**In reply please quote:** 19/29449  
**Your reference:** SSI-9364

Transport Assessments  
Department of Planning, Industry and Environment  
4 Parramatta Square  
PARRAMATTA 2150

## **M12 ENVIRONMENTAL IMPACT STATEMENT (EIS) – MAJOR INFRASTRUCTURE PROJECT**

Figure 2-1 Key features of the amended project

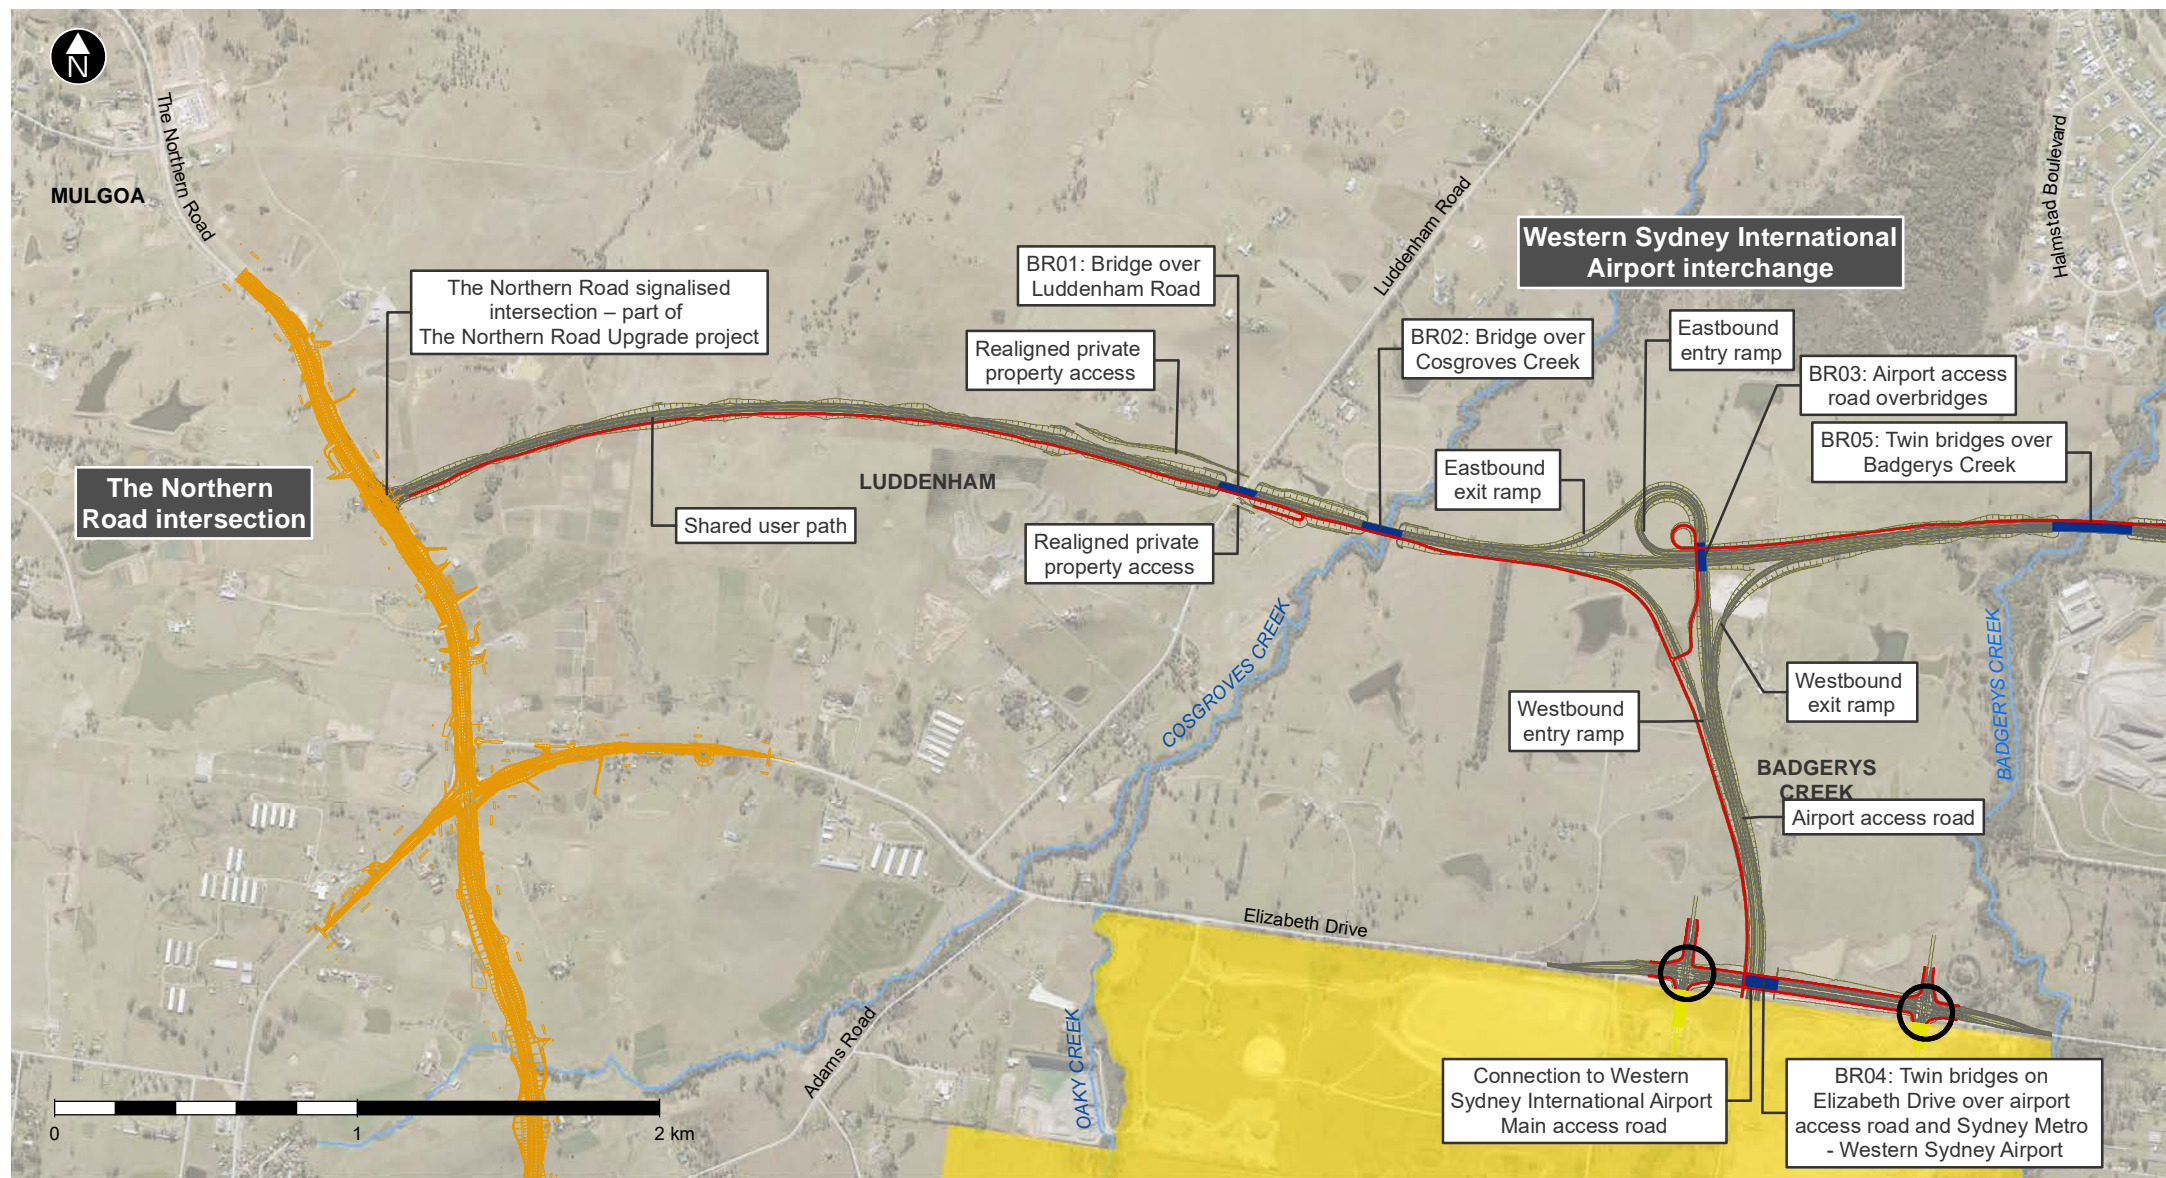
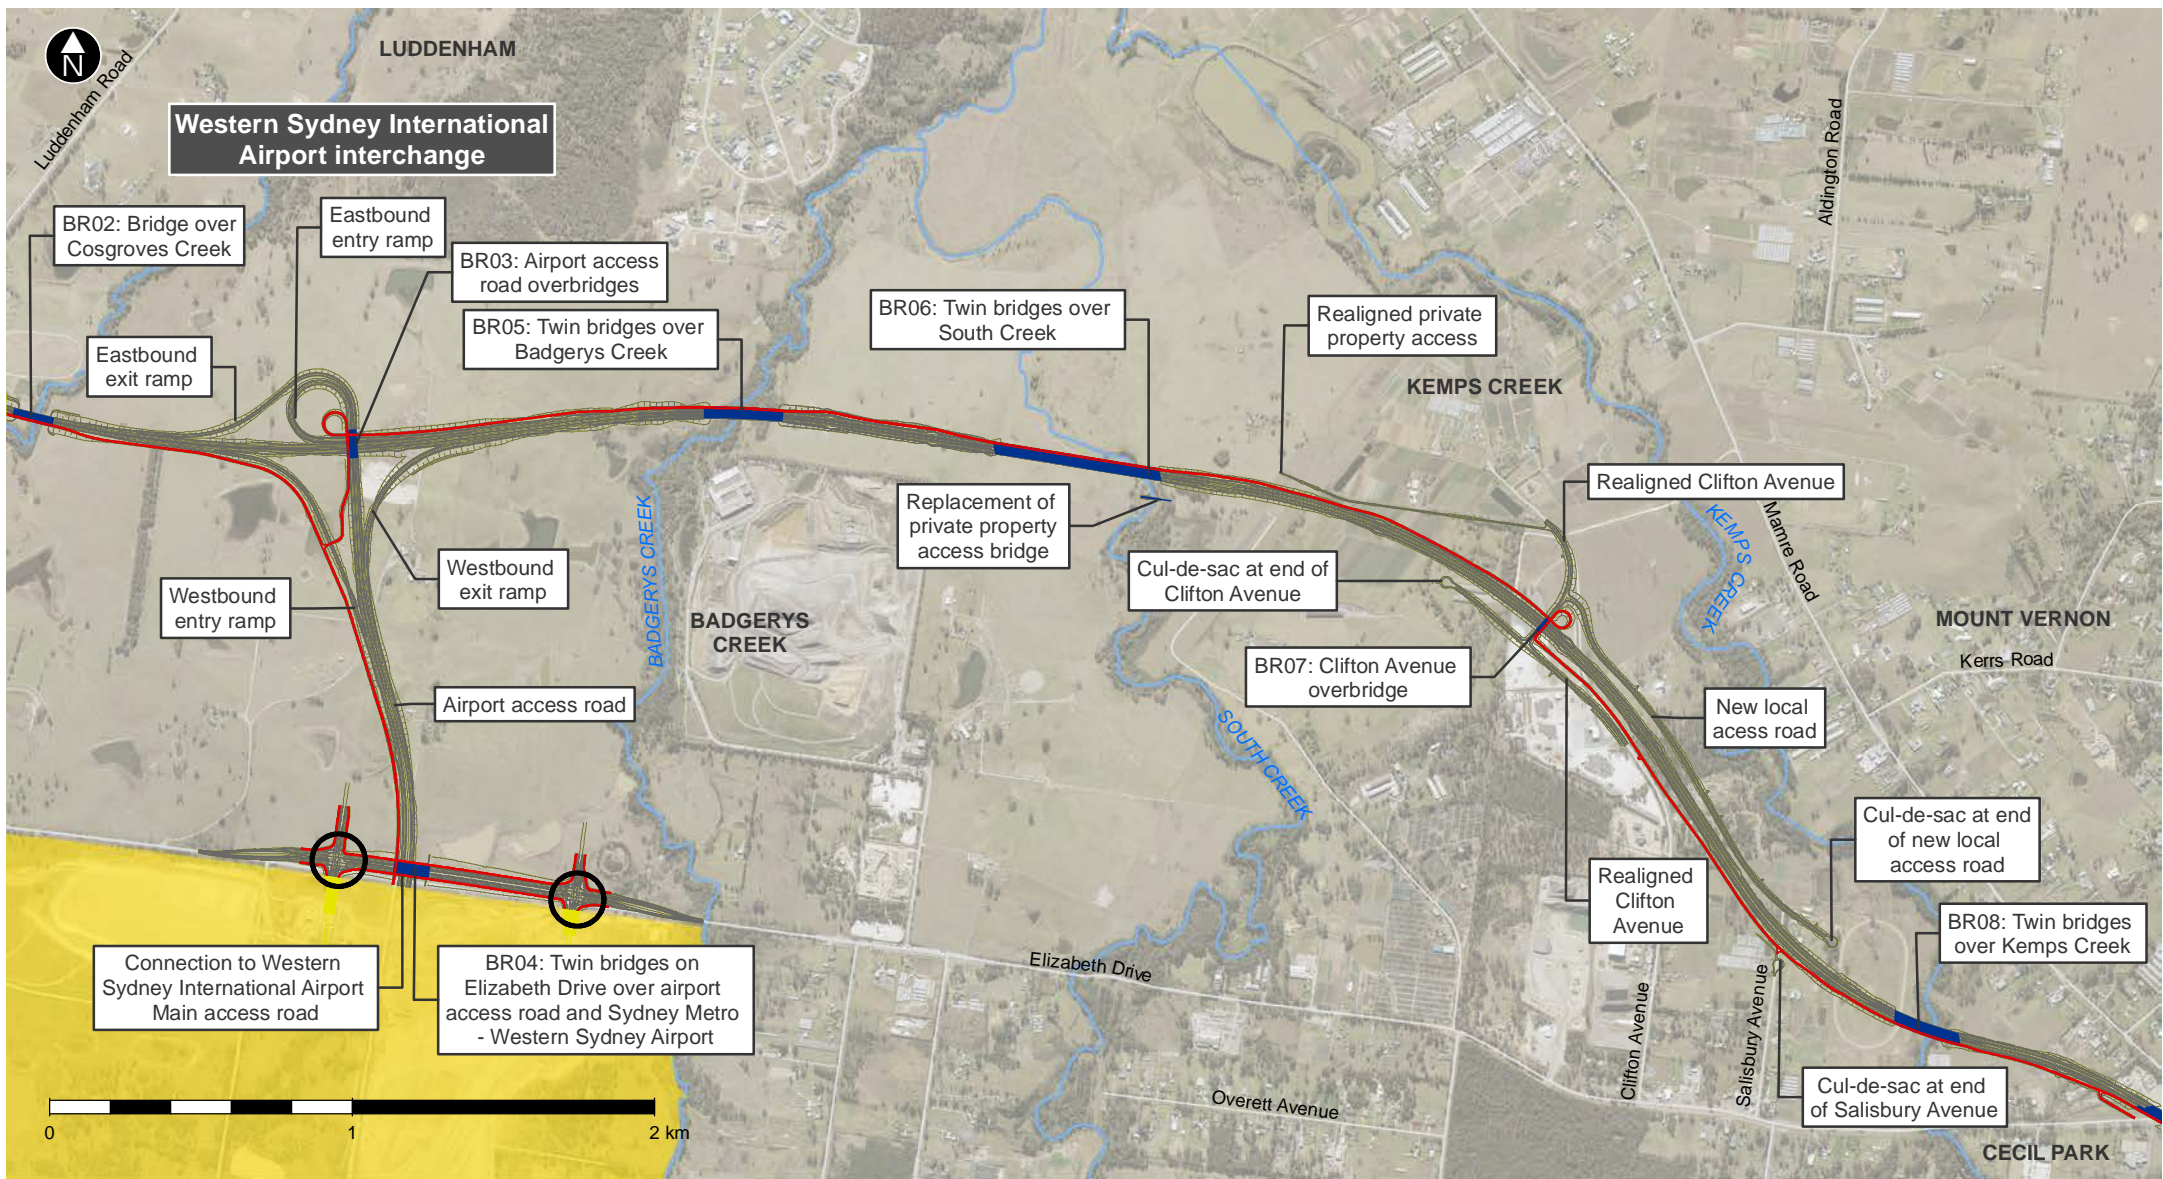
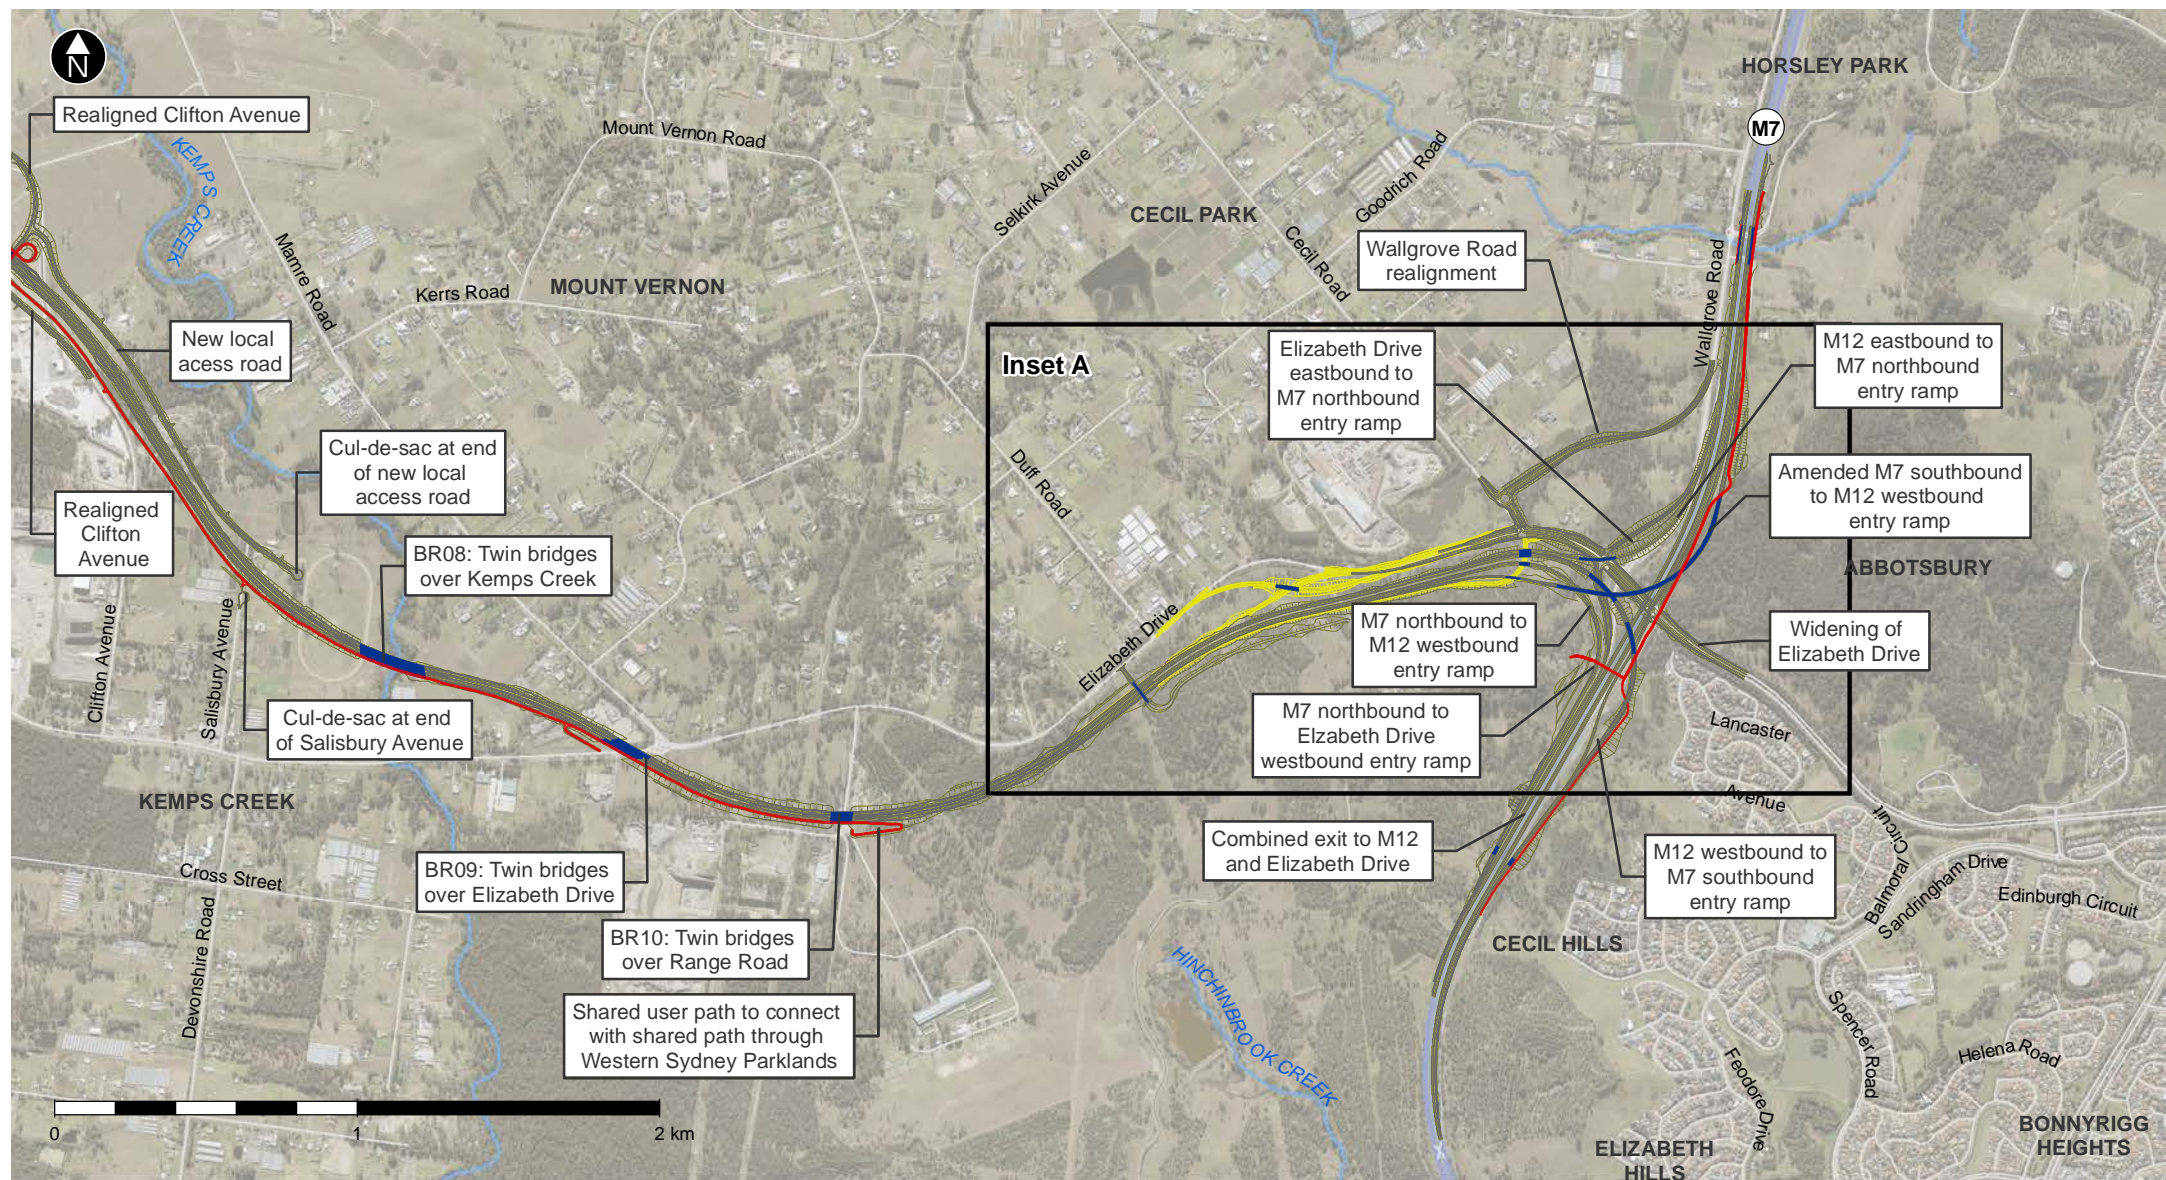
Under both Options 1 and 2 Council strongly recommends that TfNSW undertake further investigations and analysis of the proposed new roundabout at the intersection of Wallgrove Rd and Cecil Rd and new signalised intersection of Cecil Rd and Elizabeth Drive. Under the current amended design there would appear to insufficient distance between the two intersections to allow for queuing of traffic that could undermine the performance and traffic safety levels of the intersections and associated road network.

- While Option 2 is preferred, what is not clear is the expected diversion of traffic onto the local road network with this option i.e. proceeding straight onto Cecil Road instead of turning right into Wallgrove Rd.

- The traffic model needs to be amended to assess the impact on the local road and what actions need to occur to address these impacts with the advent of the M12 (the traffic model was not amended to accurately reflect the Wallgrove Road deviation across to Cecil Road).

- Council suggests that the road corridor needs to be sized now to accommodate future upgrade to traffic control signals at the new Cecil Road/Wallgrove Road intersection i.e. land acquired as part of the project for 4 lanes plus turn bay/bus priority/cycle infrastructure.

- Under Option 2, the creation of ramps between the M12 Motorway and Elizabeth Drive, Cecil Road and Wallgrove Road is considered a baseline requirement i.e. not dependent on additional funding.
